CITY OF ALBUQUERQUE

**Re: Renovation Building Shell
10921 Central Ave. NE
30-Day Temporary Certificate of Occupancy
Transportation Development Final Inspection**
Architect's Stamp dated 01-26-24 (L21-D030)
Certification dated 02-14-25

TCL

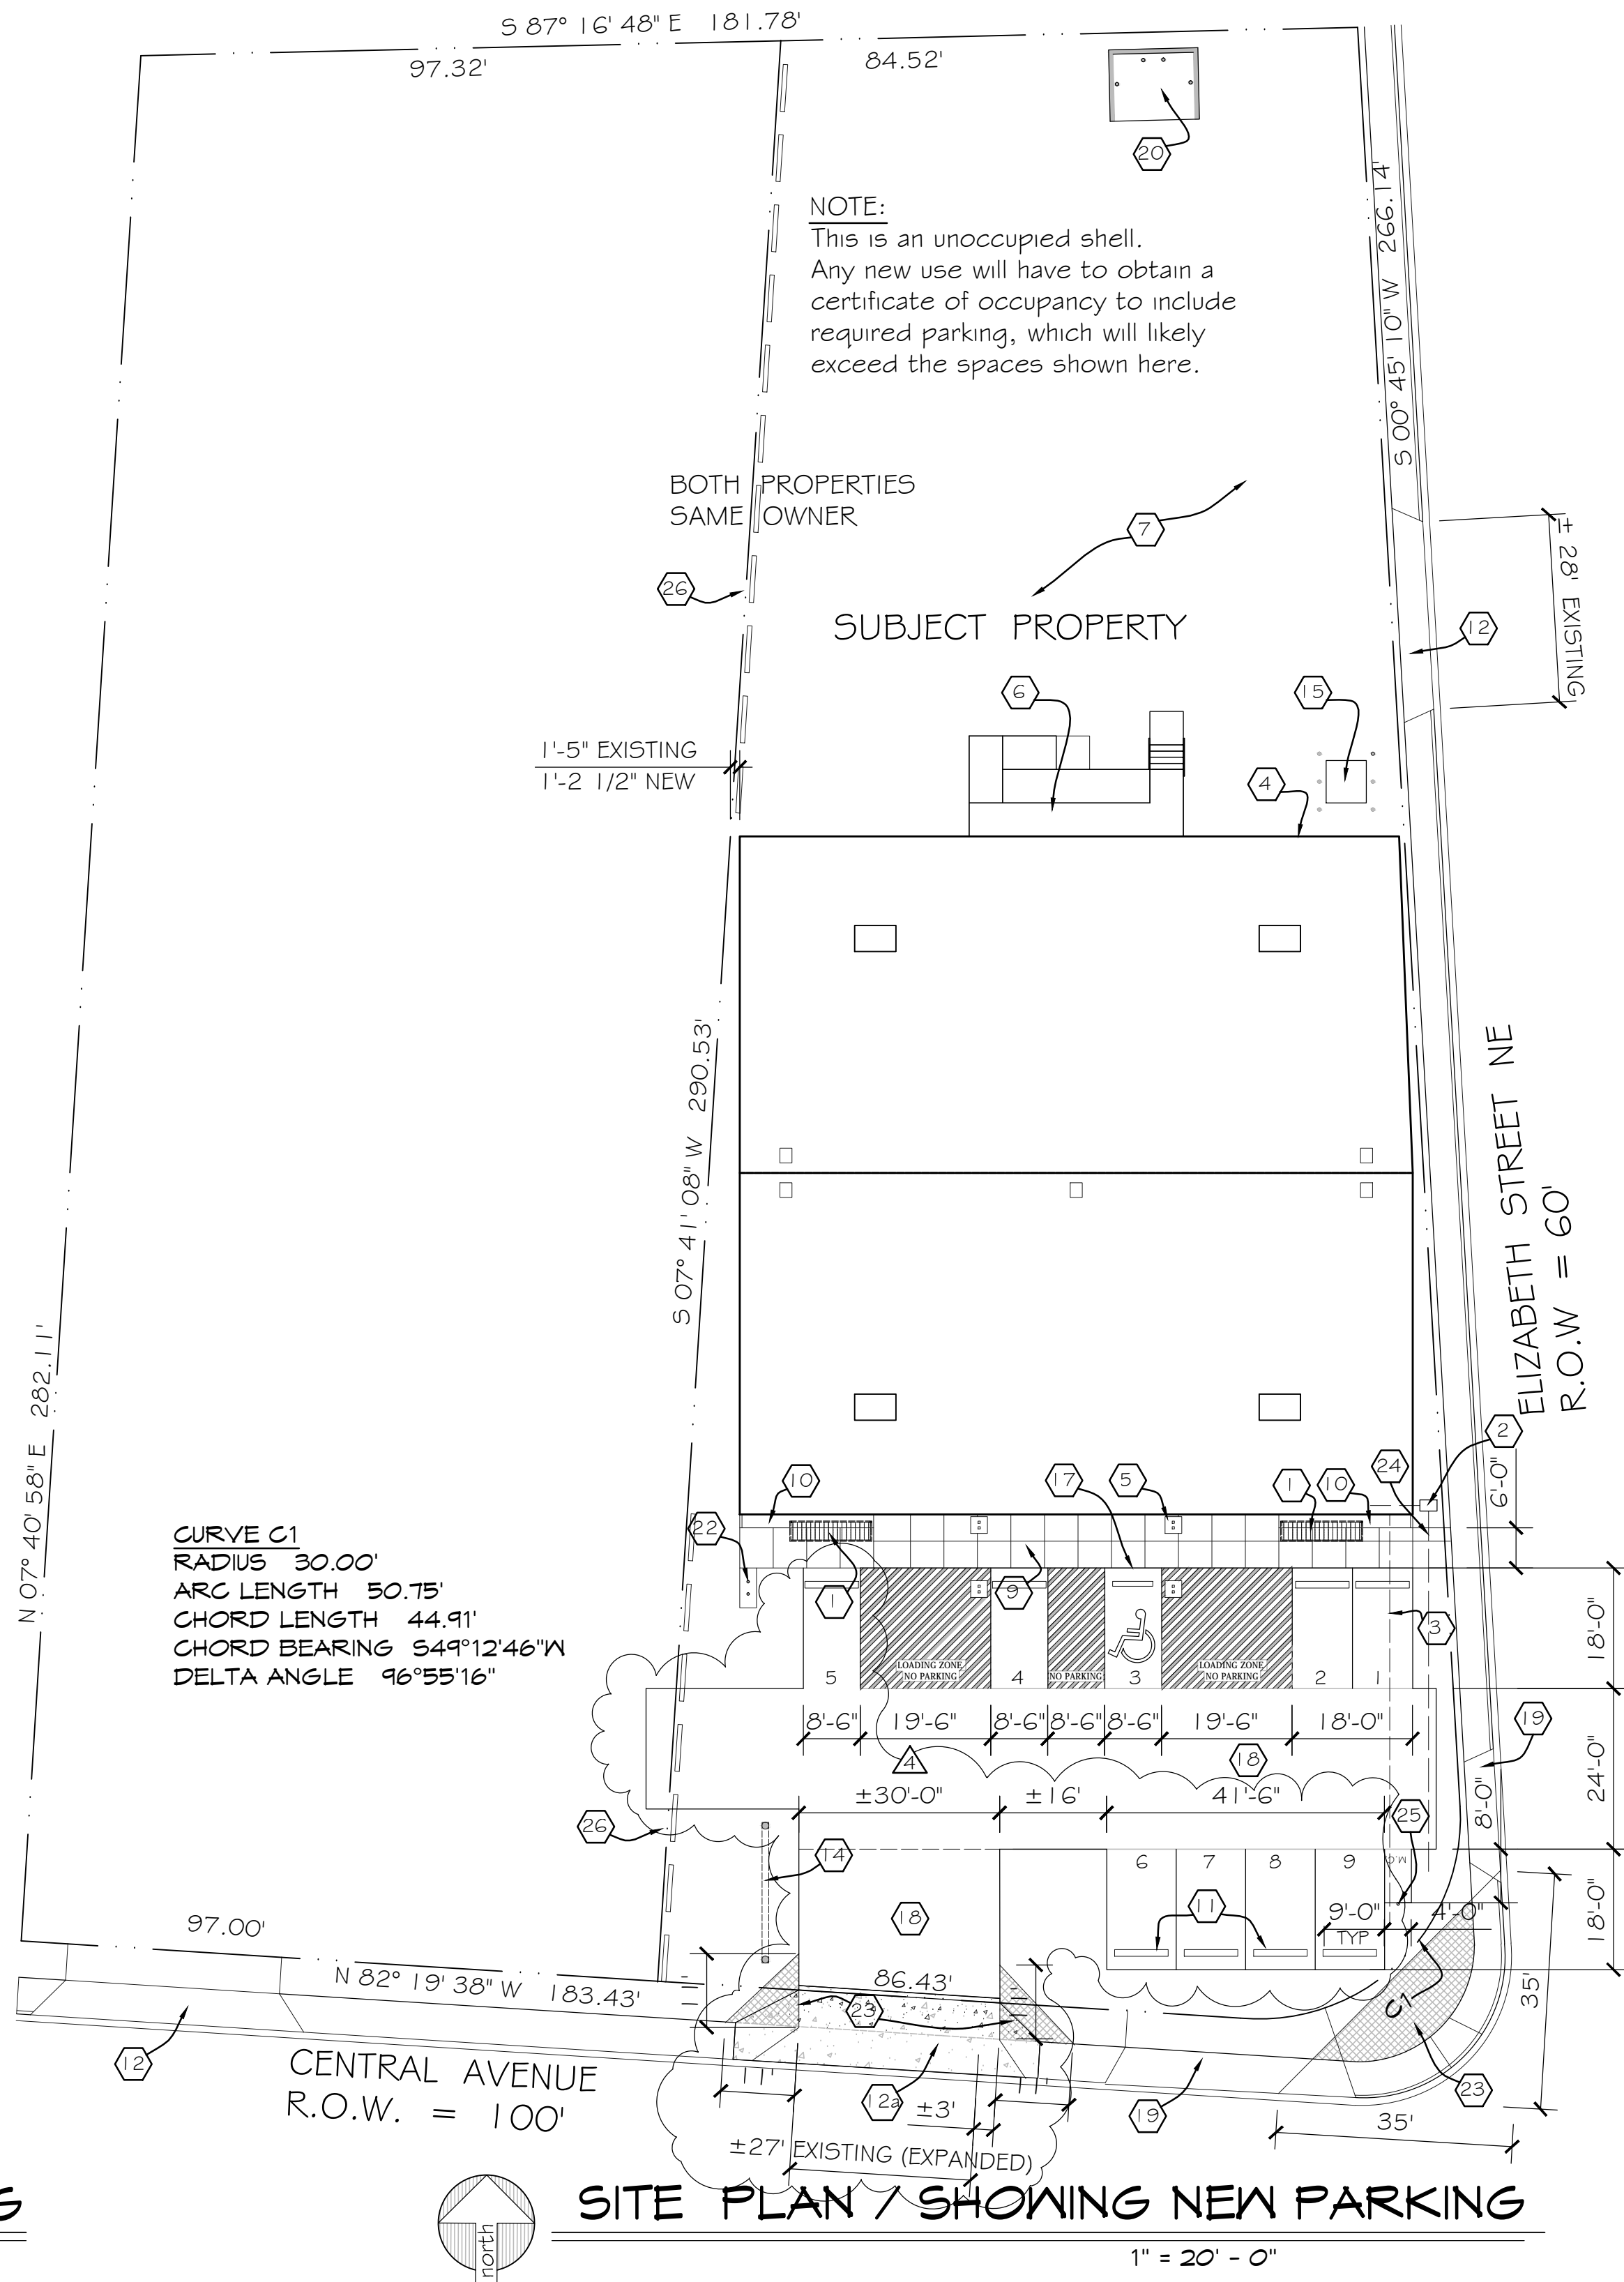
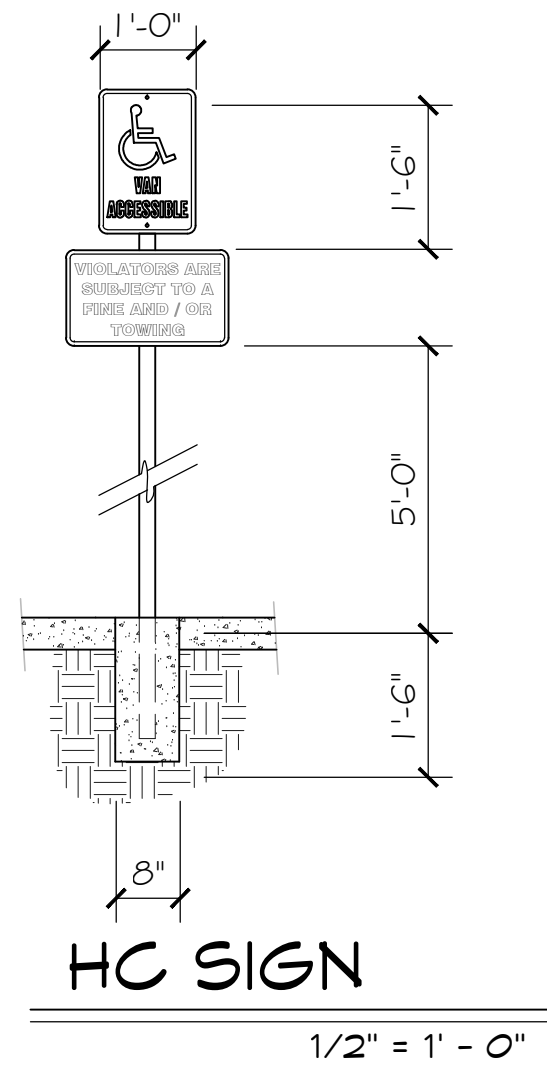
- Per approved plan keynote 12: the site access off Elizabeth St. must be ADA compliance.
- Anchor down Bike Rack.
